20 April 2016

Our Reference: SYD15/01051/02 (A12585290)  
DP&E Ref: SSD 7155

**PROPOSED WAREHOUSE AND DISTRIBUTION CENTRE  
YARRUNGA STREET, PRESTONS**

**APPENDIX E – BERNERA ROAD UPGRADE AND INTERSECTION WORKS**

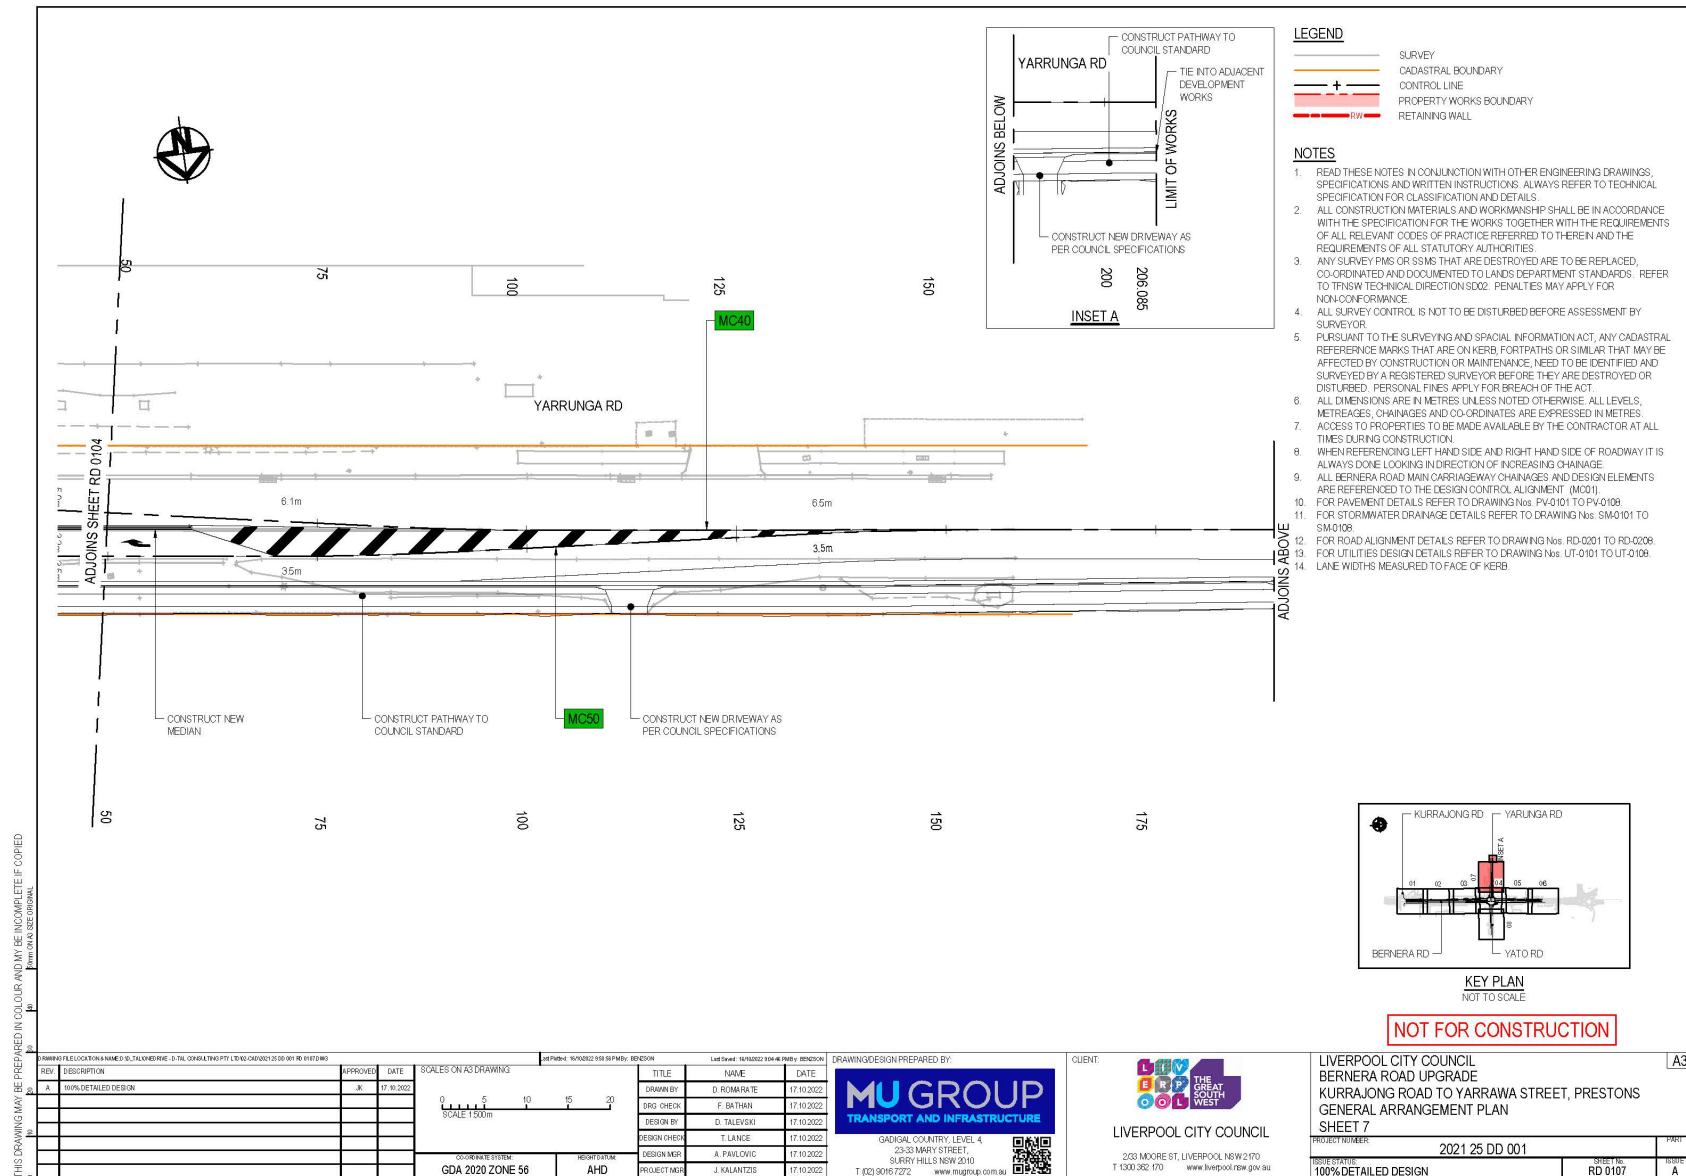
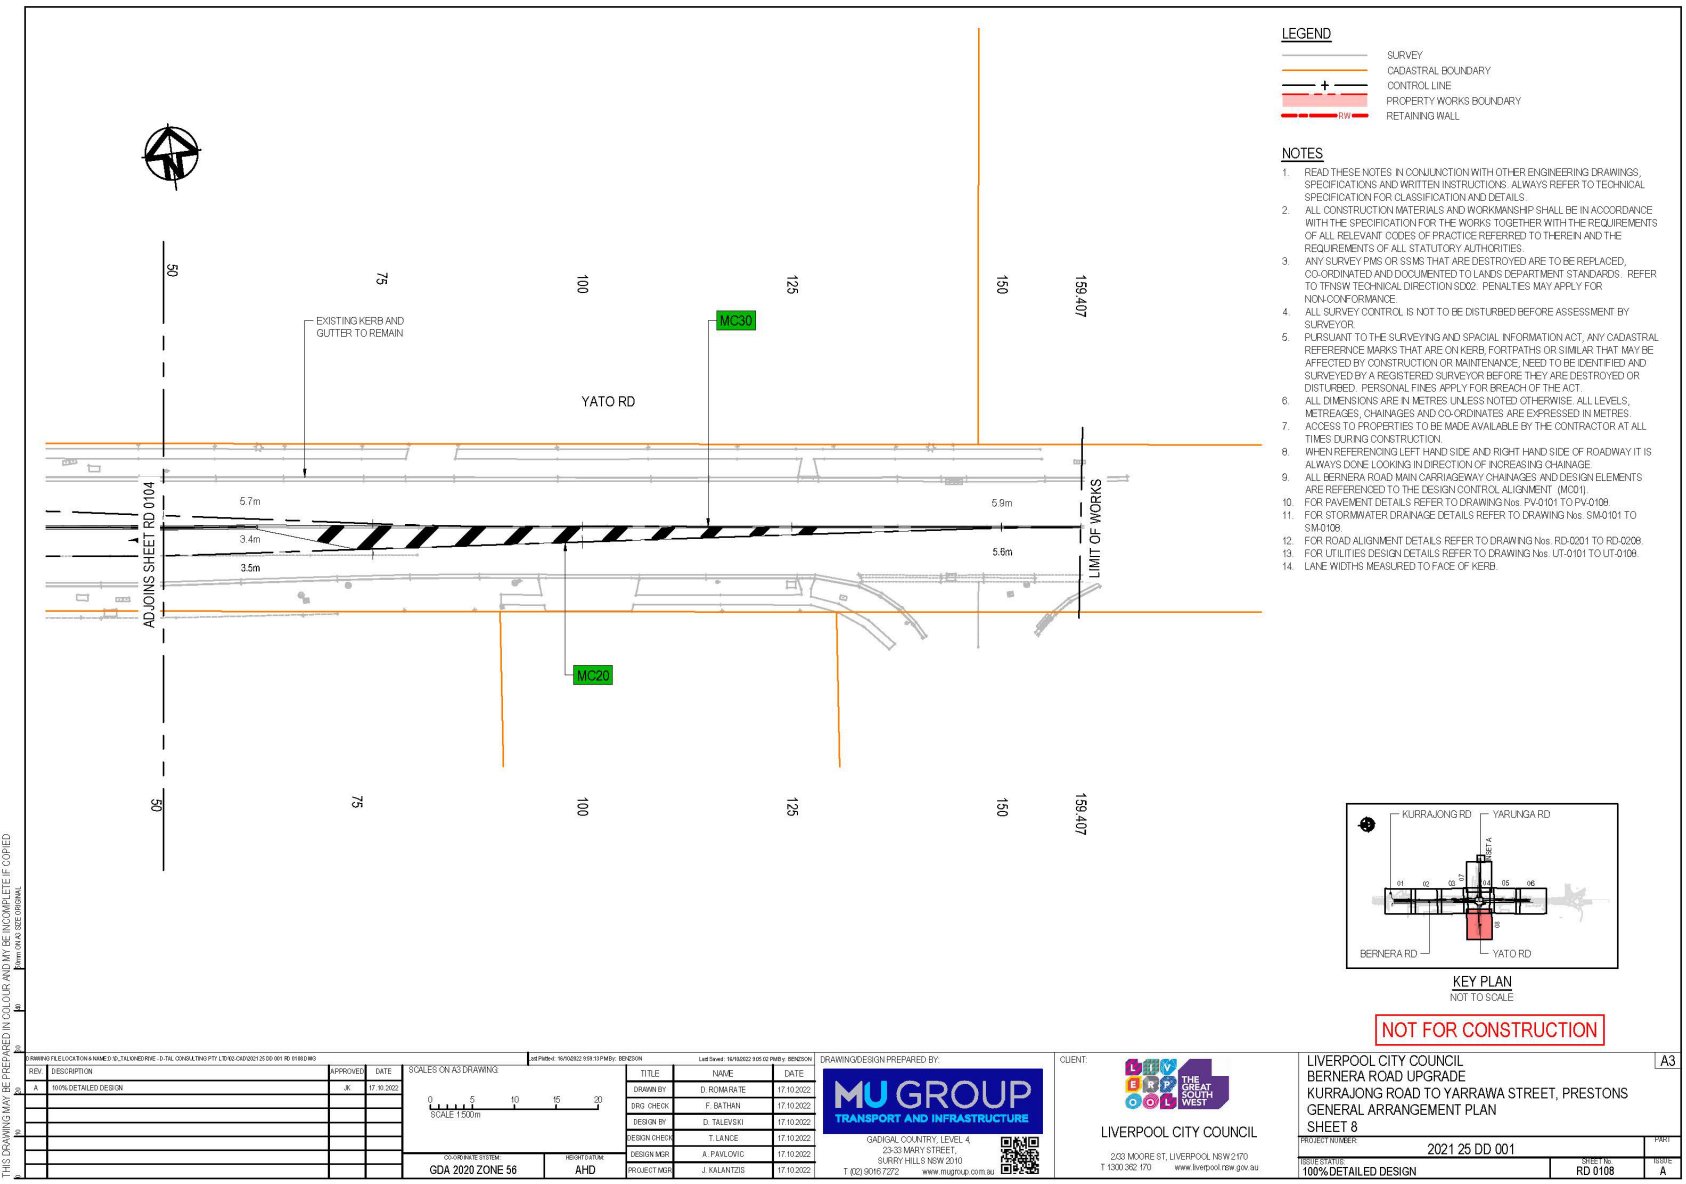
1. It is advised that a 26m B-double truck should be used as a design vehicle for the extent of works required on the intersection. The swept path plan should be modified showing turning path of a 26m B-double on the south western corner of the intersection to cater for the left turn movement of articulated vehicles accessing the site.
2. A large number of 19m semi-trailers access the Aldi warehouse located east of the site via Yato Road. In this regard, swept path plans should be provided and submitted for review showing that the signals will operate as a double diamond using a 26m B-double and 19m semi-trailer as design vehicles.

3. There are two existing kerb pits that will be affected by the new works and are proposed to be converted to buried junction pits with lids. Calculations are required showing that the width of flow for the two pedestrian crossing on the south western corner of the intersection do not exceed 0.5m for a 1 in 10 year storm.

4. Roads and Maritime does not support the proposed combined pedestrian crossing at the intersection. The Pedestrian crossing should be separated and plans should be modified reflecting this requirement.

5. Roads and Maritime requests installing physical medians in the side streets at the intersection to restrict turning trucks crossing over the centre line onto the side street detectors which result in changing the signals for the phases.
